Proposed Redevelopment Development 23-37 Lindfield Avenue & 11 Havilah Lane, Lindfield Heritage Response (MP08_0244 MOD 1)

Further to our recent discussions and a review of the relevant material from Ku-ring-gai Council and the Department of Planning and Infrastructure, we have pleasure in providing this additional heritage impact commentary regarding the modified proposal.

1 KOCHIA LA ELEVATION
SCALE 1 : 250

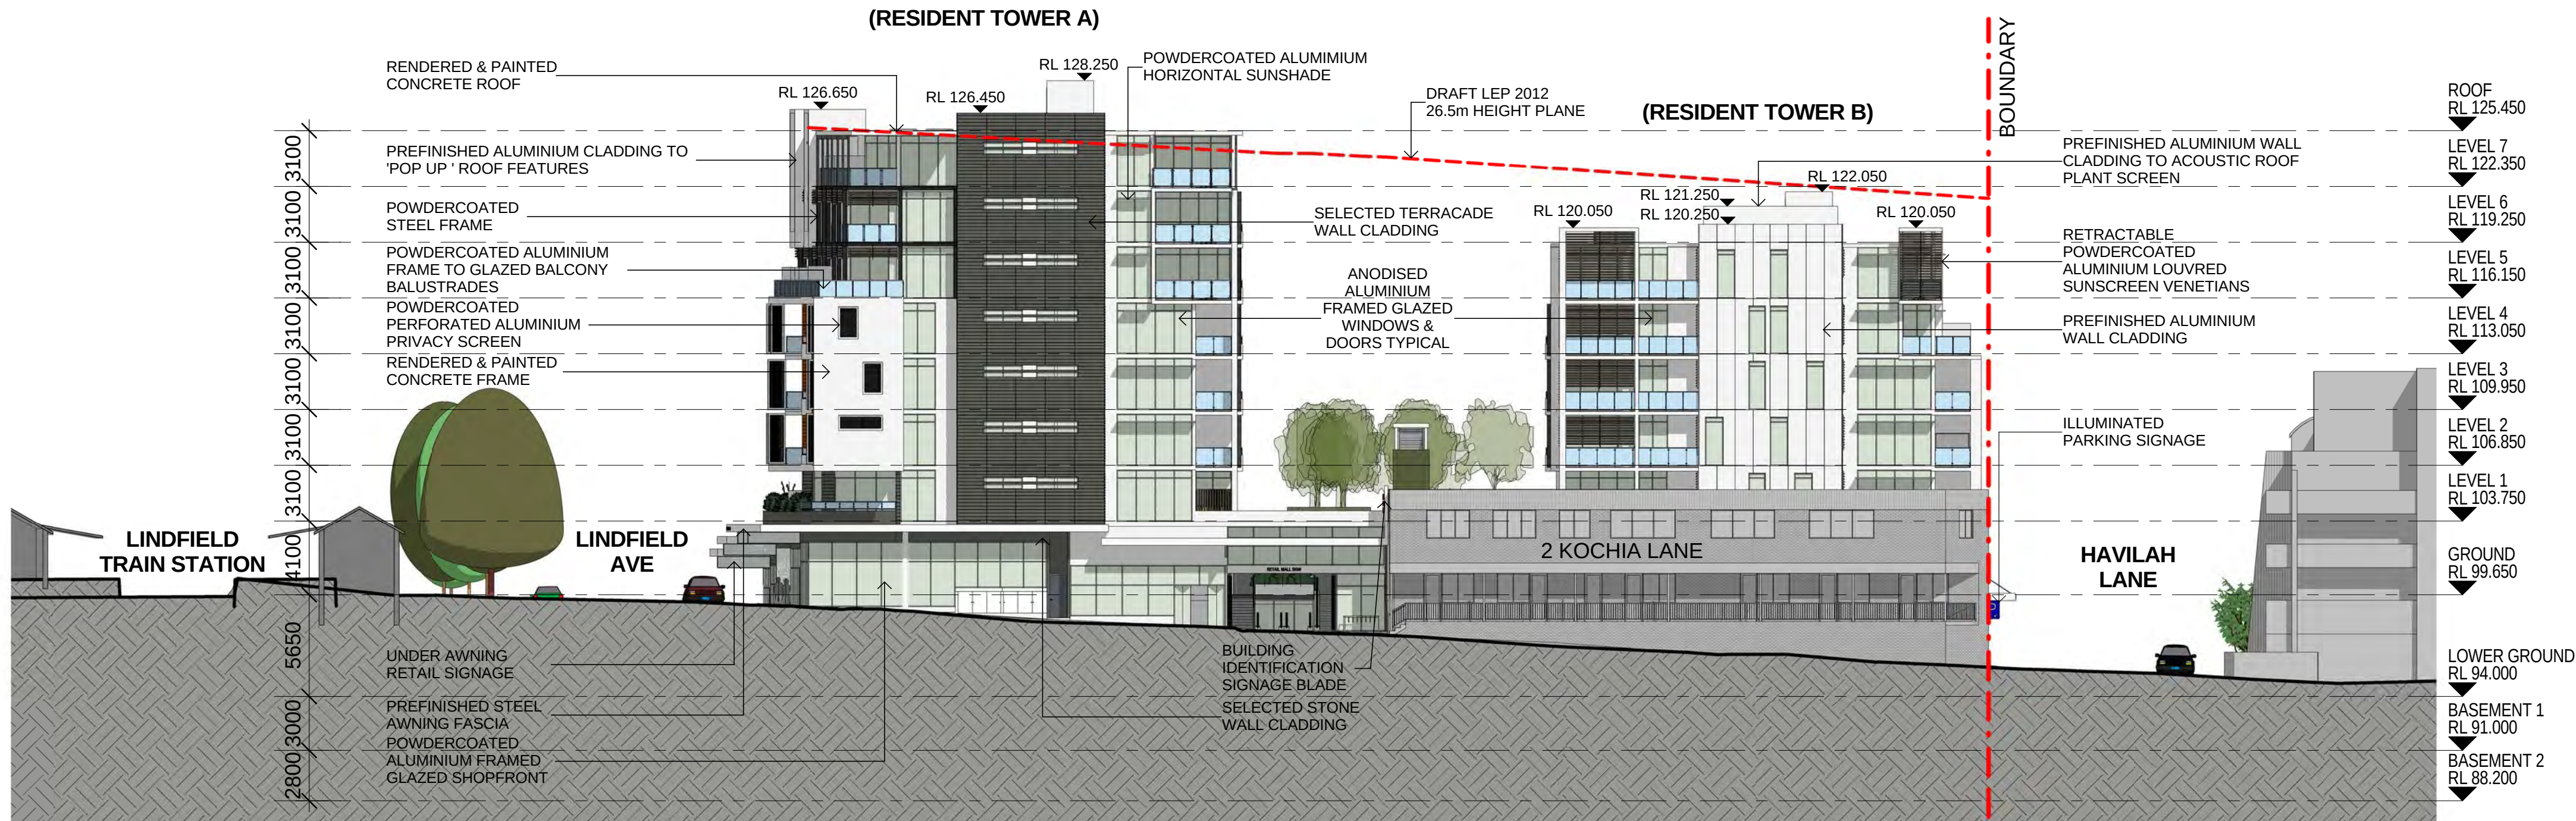
Council has expressed concern about the encroachment of the upper levels of the building into the 4m setback to Kochia Lane and has requested that all encroachments into the area be eliminated. The Department notes that this strip of land is to be dedicated to Council to facilitate the widening of the laneway, consistent with Council's Public Domain Plan.

Further justification of these encroachments into the setback area and their impact on the future amenity and functionality of the space (having regard to Council's intentions for Kochia Lane), is required.

We have been advised that there are no functional reasons why Council should be requesting the removal of the cantilevered section of the new building from above Kochia Lane. The cantilever is sufficiently high to provide adequate pedestrian and vehicular clearance and thus meet Council's access and public domain objectives.

We do not believe that the proposed high level encroachment over Kochia Lane raises any adverse heritage impact issues in relation to the adjacent heritage building at 1-21 Lindfield Avenue. The dynamic energy imparted to the façade, and three dimensional composition of the new building by the cantilevered balconies, adds enormously to the success of its architectural composition and the way it relates to the adjoining building.

In our understanding, there is no justification for the removal of the cantilevered section of the new building.

2 LINDFIELD AVE ELEVATION
2001 SCALE1 : 250

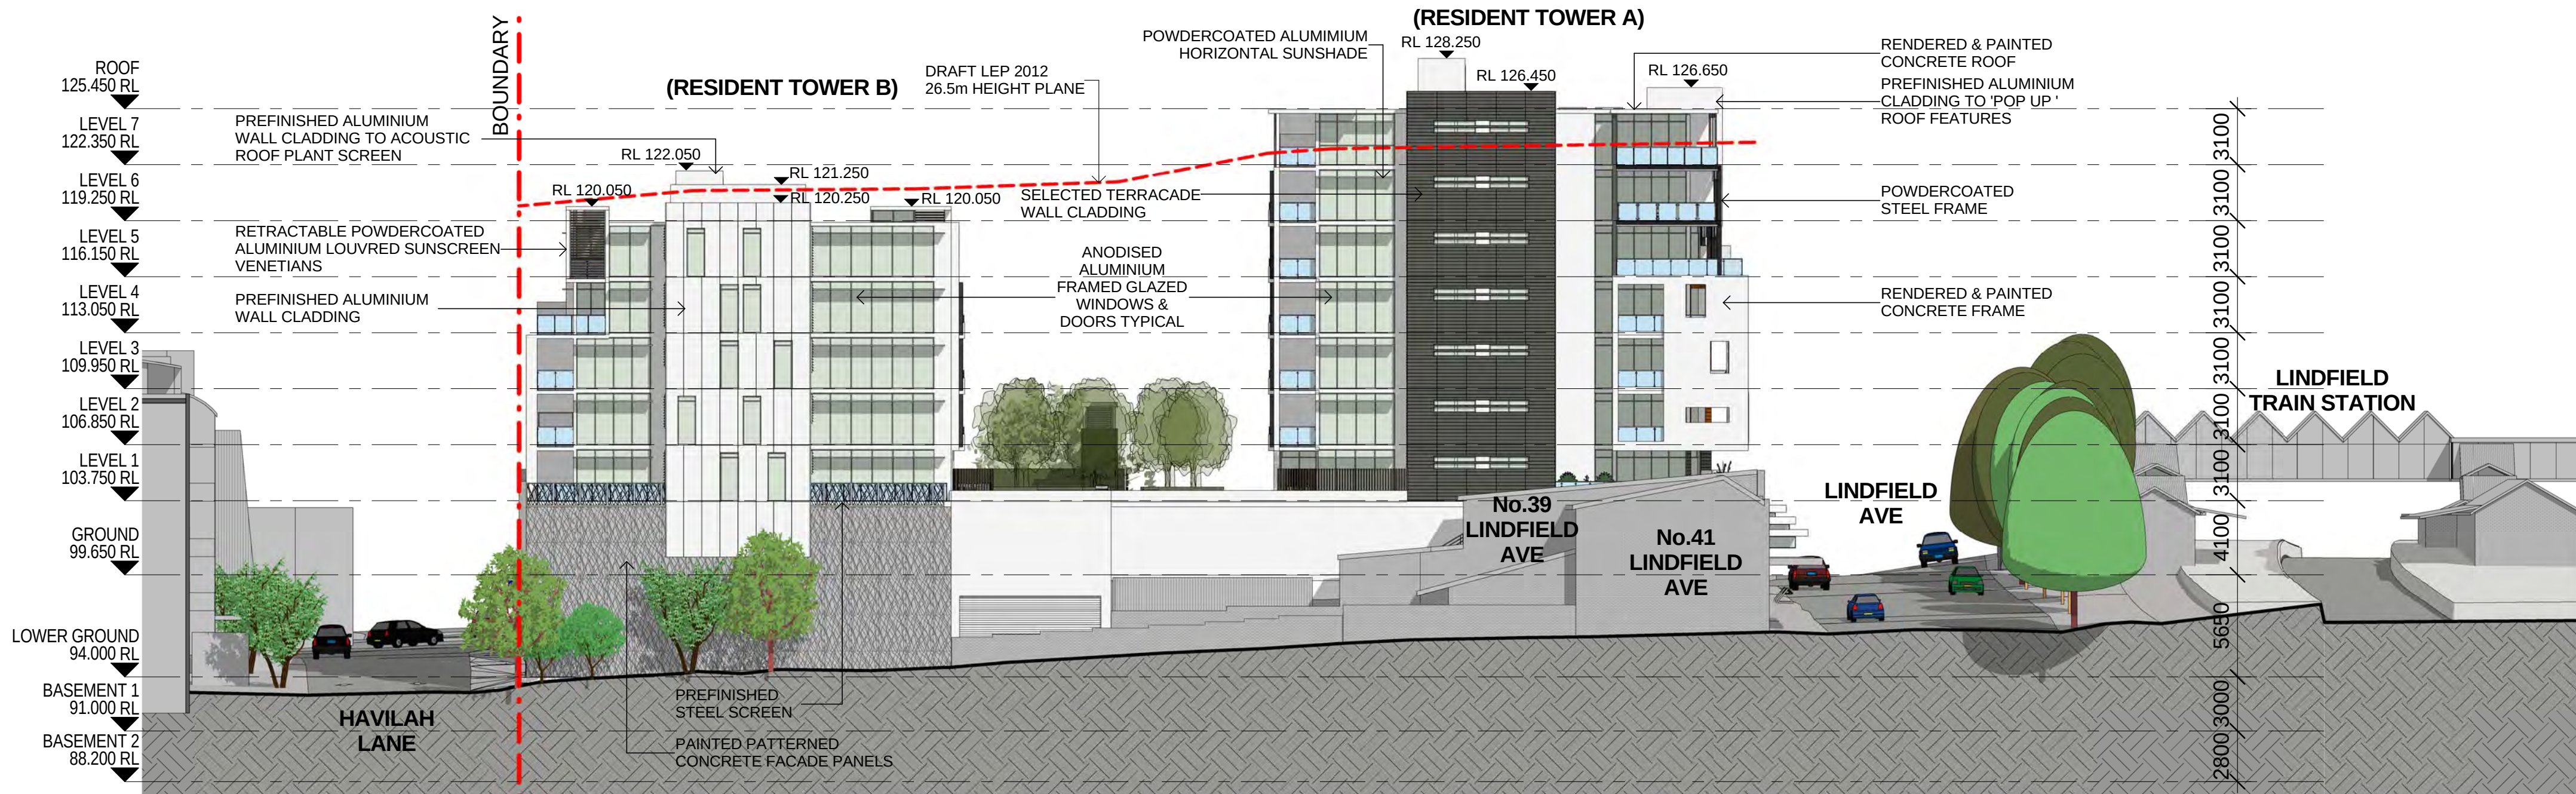
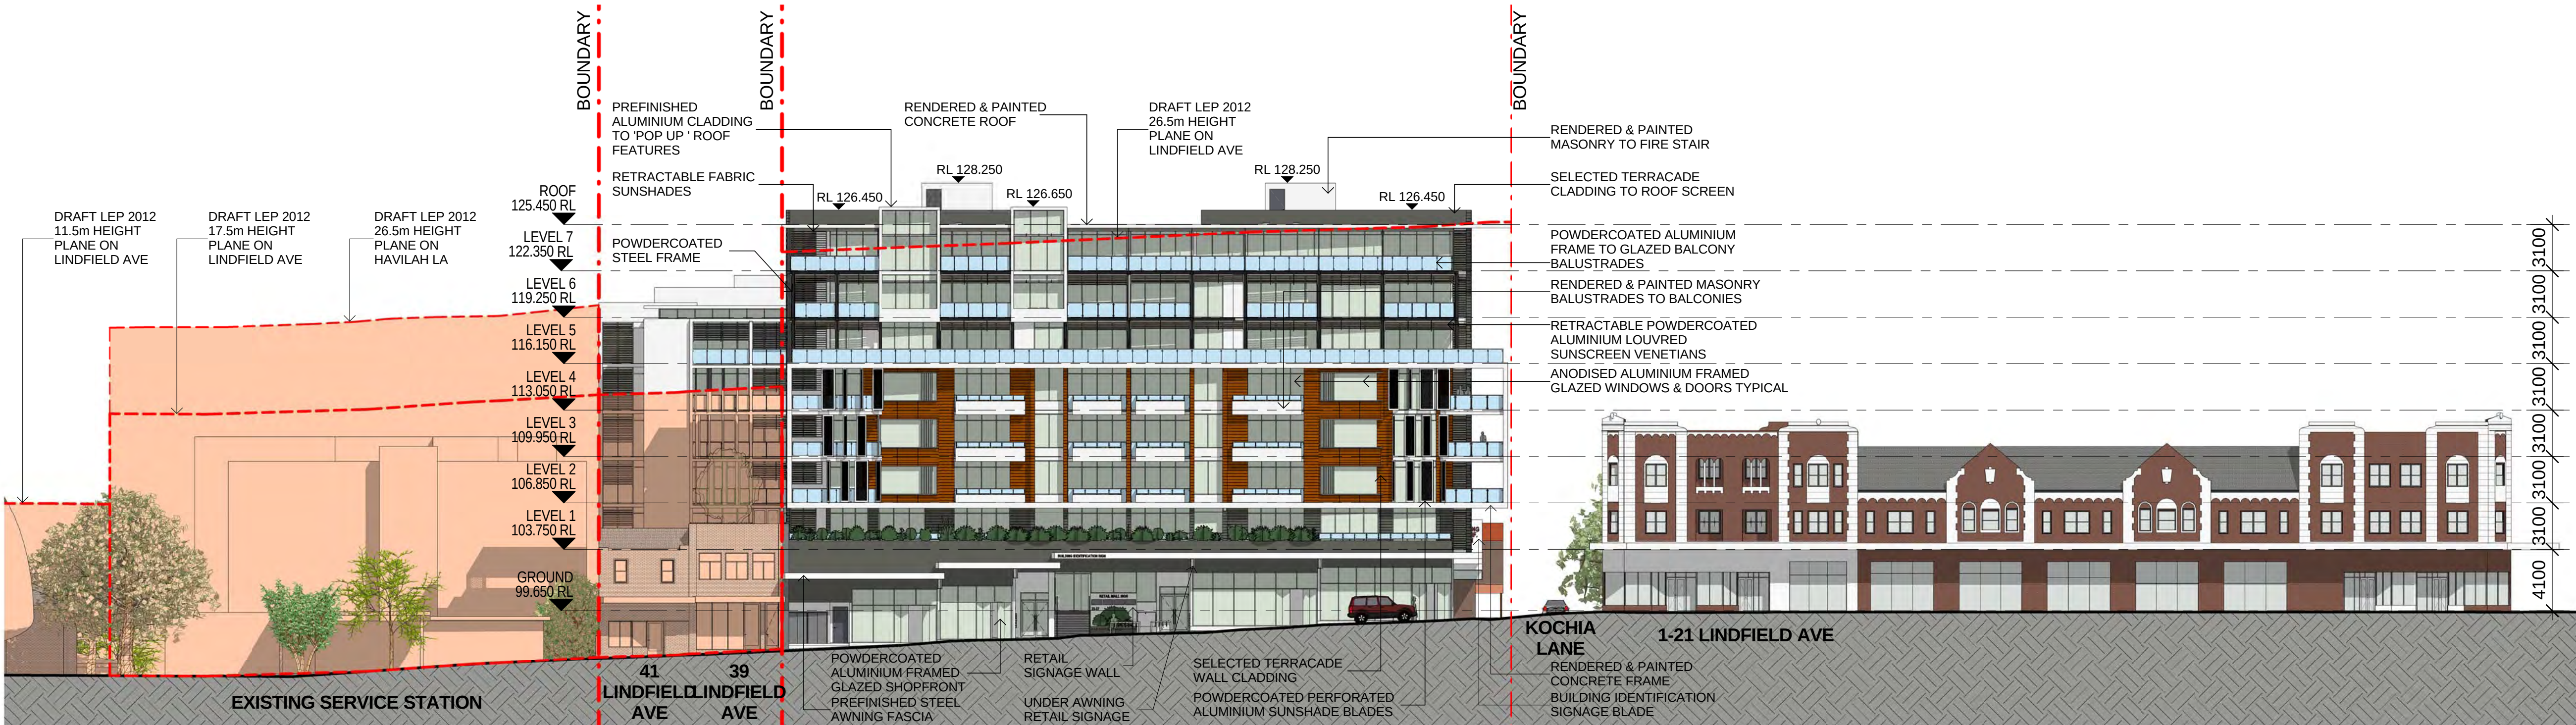
The Lindfield Avenue awning of the proposed amended design has been stepped up higher than the existing awning to better align with the awning of the historic building across Kochia Lane.

The RL of the awning of the nearby historic building is RL 104.22. The existing shopping centre awning is RL 102.44. The proposed shopping centre awning is RL 103.55, which is 1.11m higher than the current awning on the subject site. Given the historic building is located on the crest of the hill with a footpath level higher than the subject site, the awning relationship is acceptable and matches the traditional relationships between buildings that step up sloping topography.

We are fully in support of that amendment on heritage and streetscape grounds.
